Date: 07-May-2020
Our Ref: 2020/90862

**Application for Approval of Details Reserved by Condition
Town and Country Planning Act 1990
Planning (Listed Buildings and Conservation Areas) Act 1990**

**Discharge conditions 4, 6, 8, 10, 11 on previous permission 2018/93568 for change of use of existing unit in a mixed Class A1/A2/A3 retail development to form a mixed A1/A2/A3/A4/D2 retail and leisure development, internal alterations and reconstruction of upper level, with extension, external slide and formation of roof terrace for use as sky bar
Kingsgate Centre, King Street, Huddersfield, HD1 2QB
Application Number: 2020/90862**

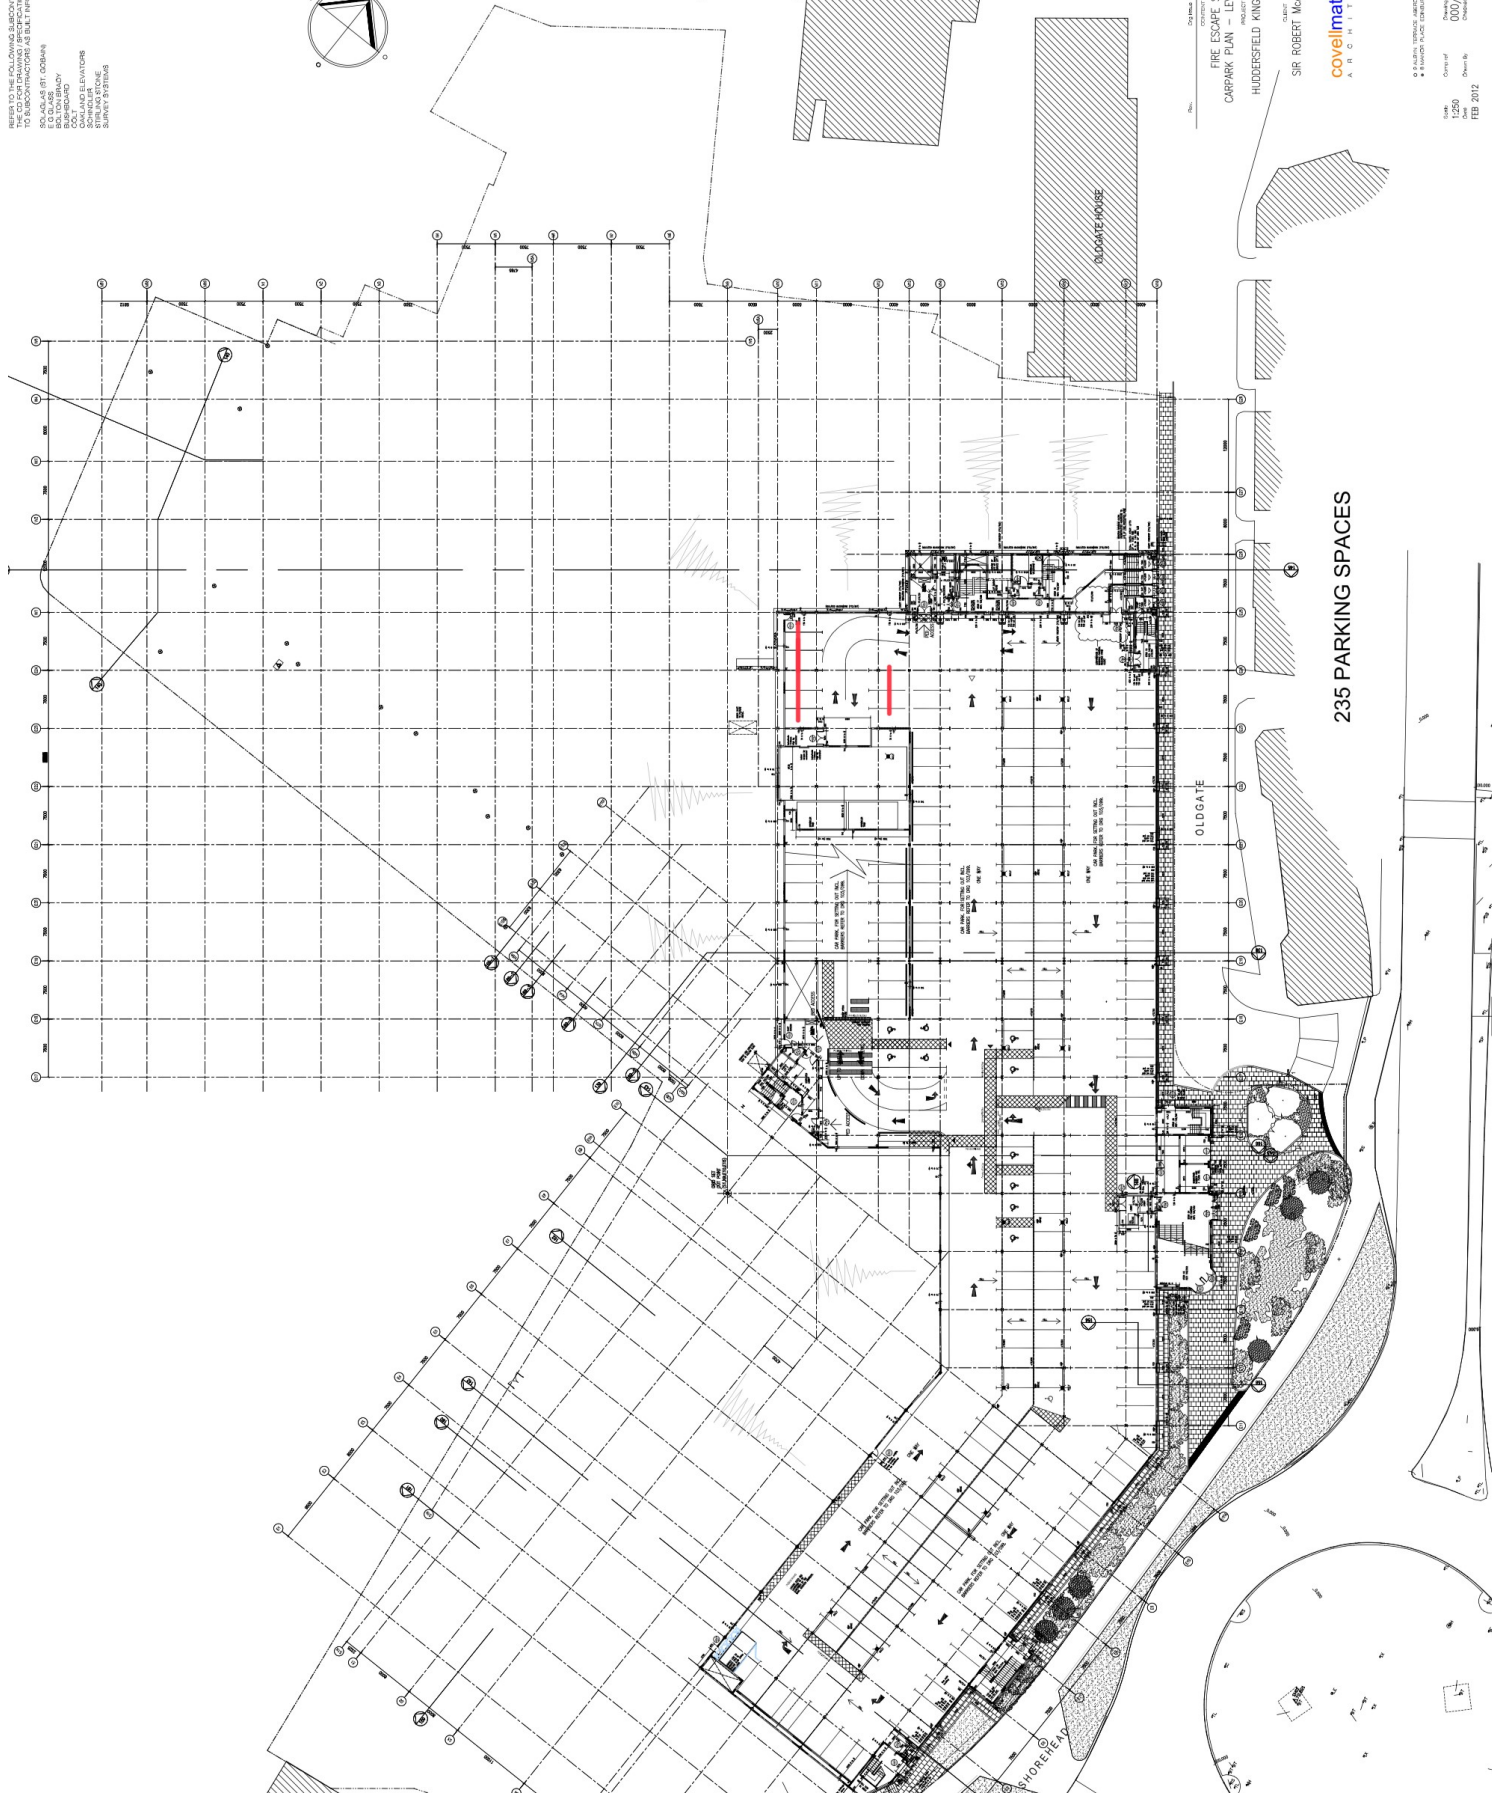
Officers accept the logic of 176 parking spaces as a starting point. However, officers would round 5% of 176 (8.8) to 9 units. Furthermore, there is no proposed trigger point for the remaining 5% of units.

Notwithstanding the above, the proposed 8 units are shown to be two different chargers that are each capable of providing a nominal 22kW per charging point. The use of Fast Charge units for the site, being a retail car park, is welcomed over slower alternatives. If it can be confirmed that all 8 units are to be 22kW units and would operate at their maximum speed, no additional charging points are sought.

It is understood that the car park is managed and that users are subjected to parking fees. It is therefore assumed that the parking bays served by the EV charging points will be managed in a way that prevents them being used by non-electric vehicles. Confirmation of how the spaces will be managed needs to be provided by the applicant.
